From: Alison Meeus [REDACTED]
Sent: 22 August 2017 09:51
To: Anita Gardner
Subject: More information

I have heard back from the engineers and they have the following questions/comments to make:-

SECTION 278 AGREEMENT PLAN Scale 1:200

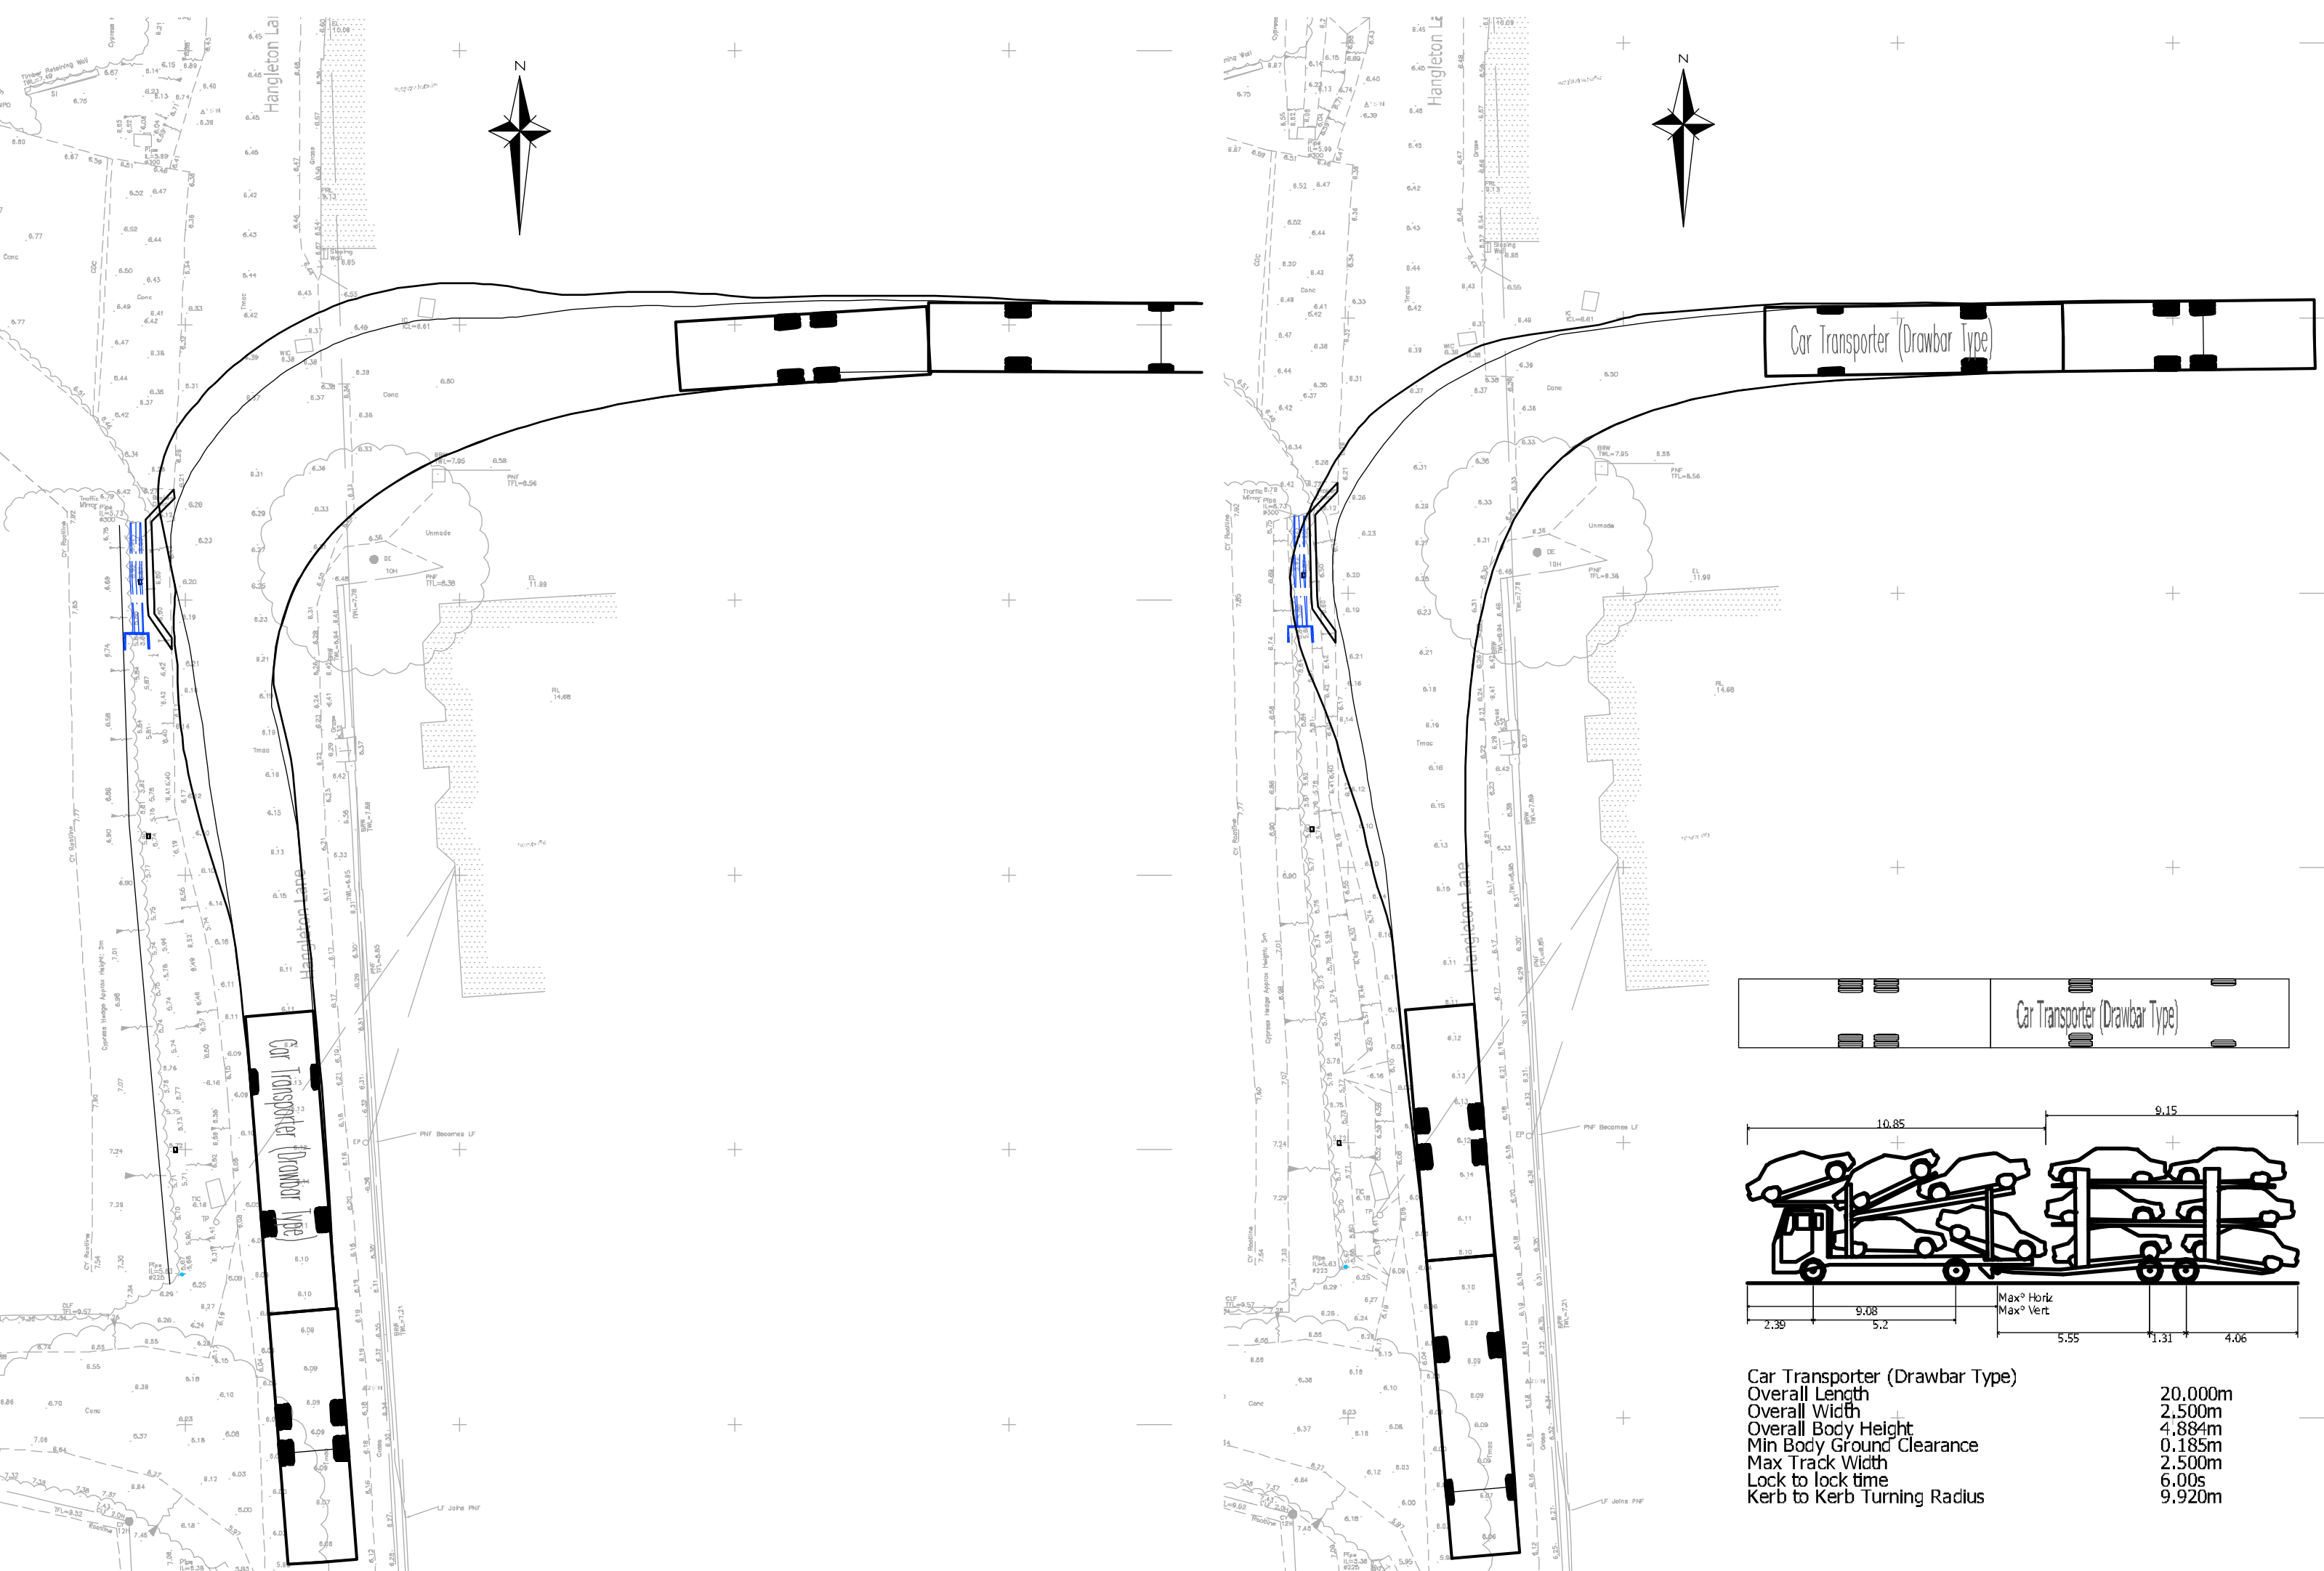
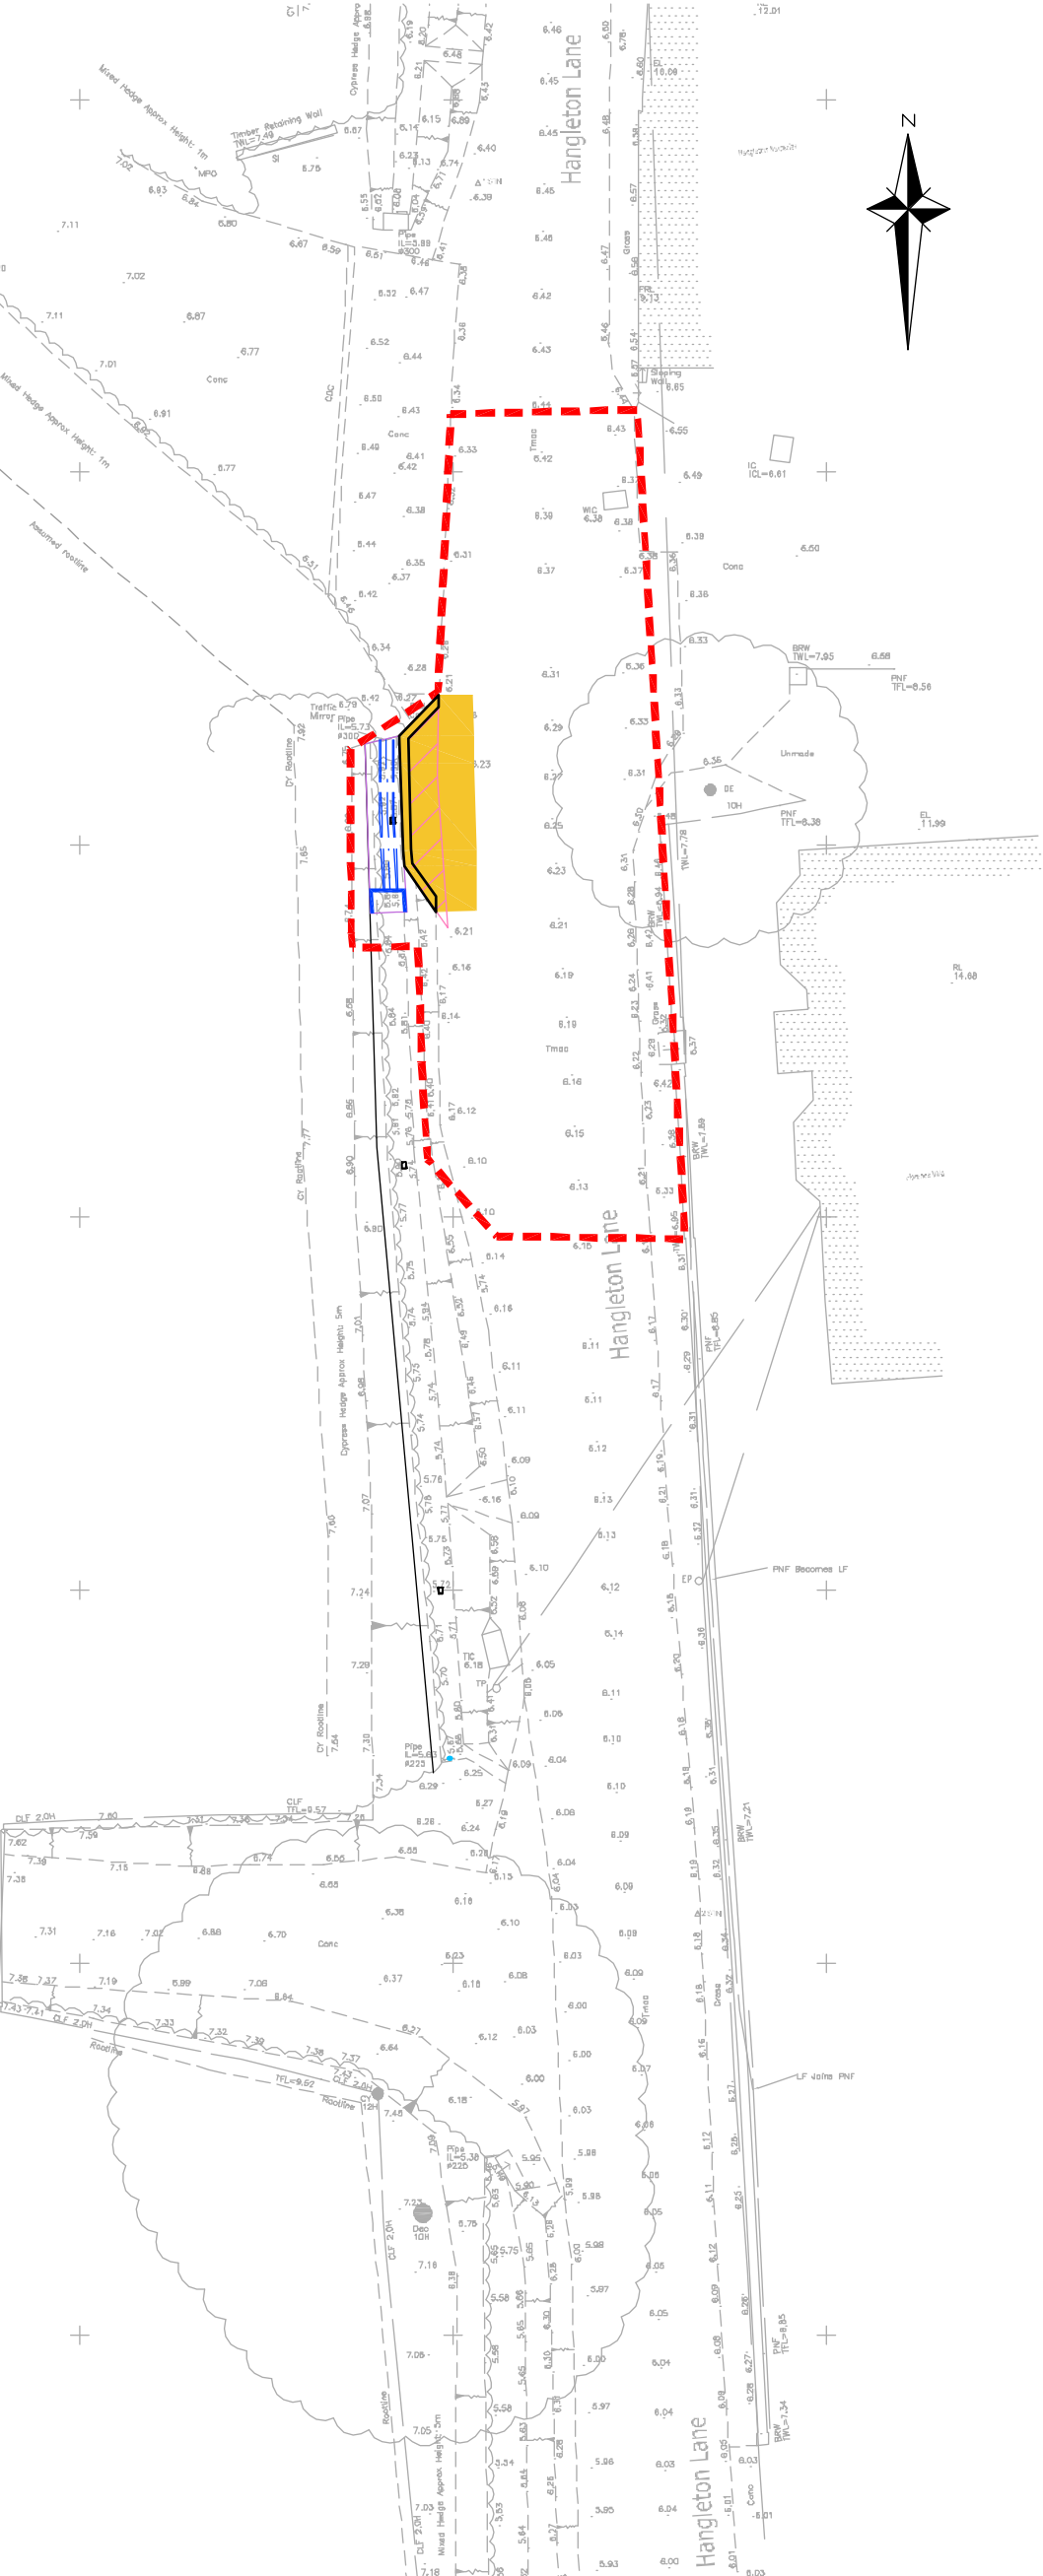
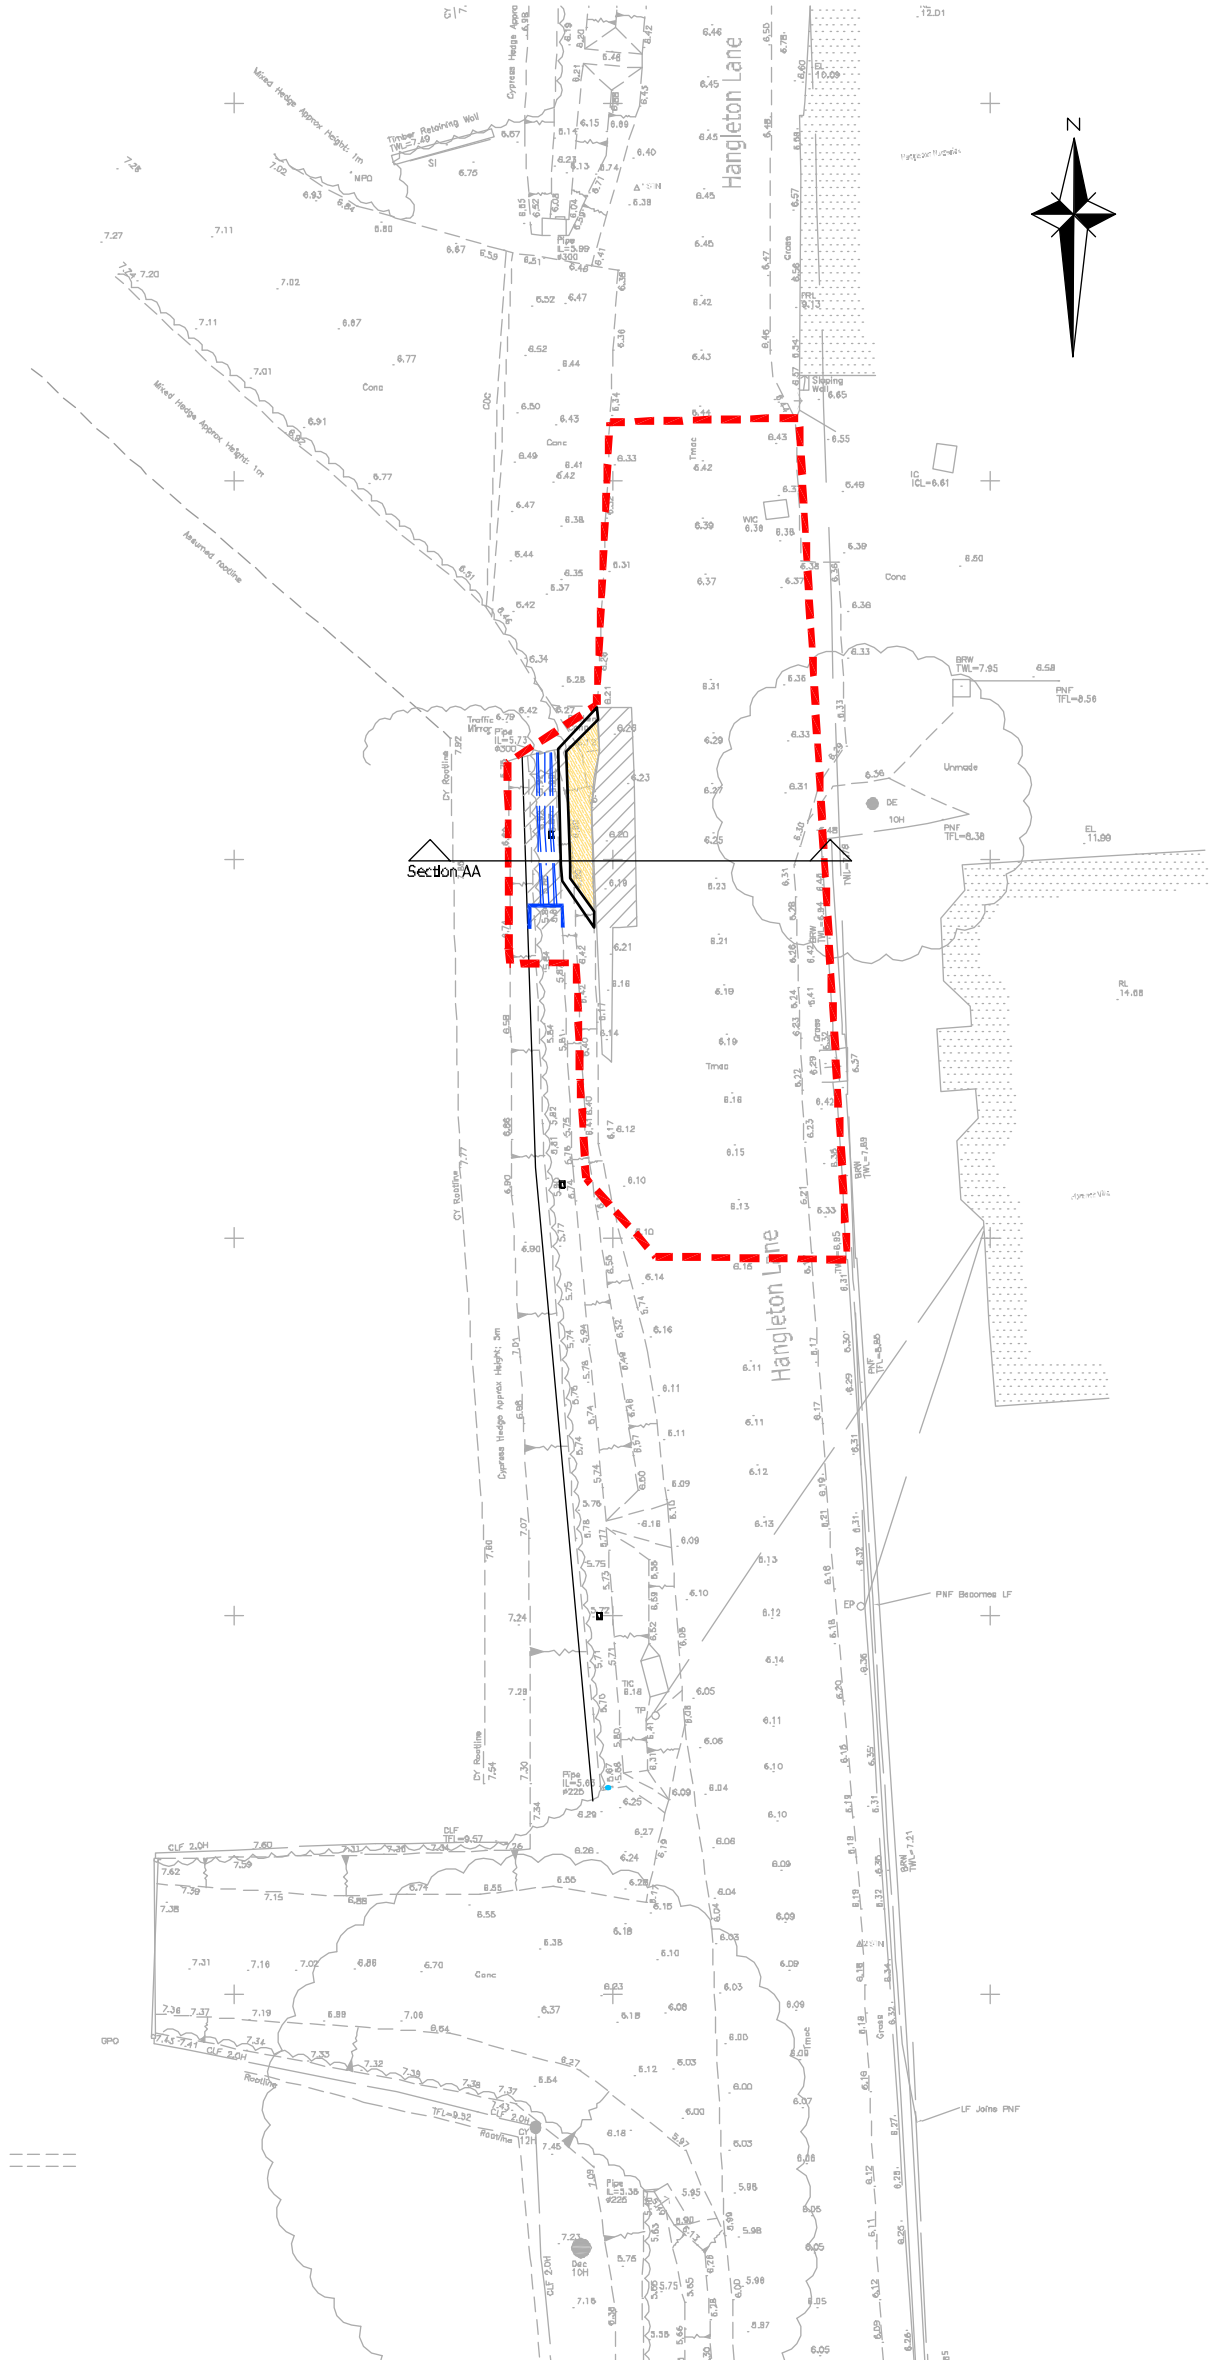
1) Some of the coloured 'S278' works seem to extend beyond the existing highway boundary, and therefore it seems likely that these works would need to take place under a S38 agreement with the consent of the landowner. We would therefore recommend the following condition

4) The detail of the construction of the widening works and the S278 agreement plan should not be approved at planning as further checking will take place as part of the S278 application.

Section 38 Agreement of the 1980 Highways Act – Provision of Adoptable Highway

The applicant is advised to enter into a legal agreement with West Sussex County Council, as Highway Authority, to cover the proposed adoptable on-site highway works. The applicant is requested to contact The Implementation Team Leader [REDACTED] to commence this process. The applicant is advised that any works commenced prior to the S38 agreement being in place are undertaken at their own risk.
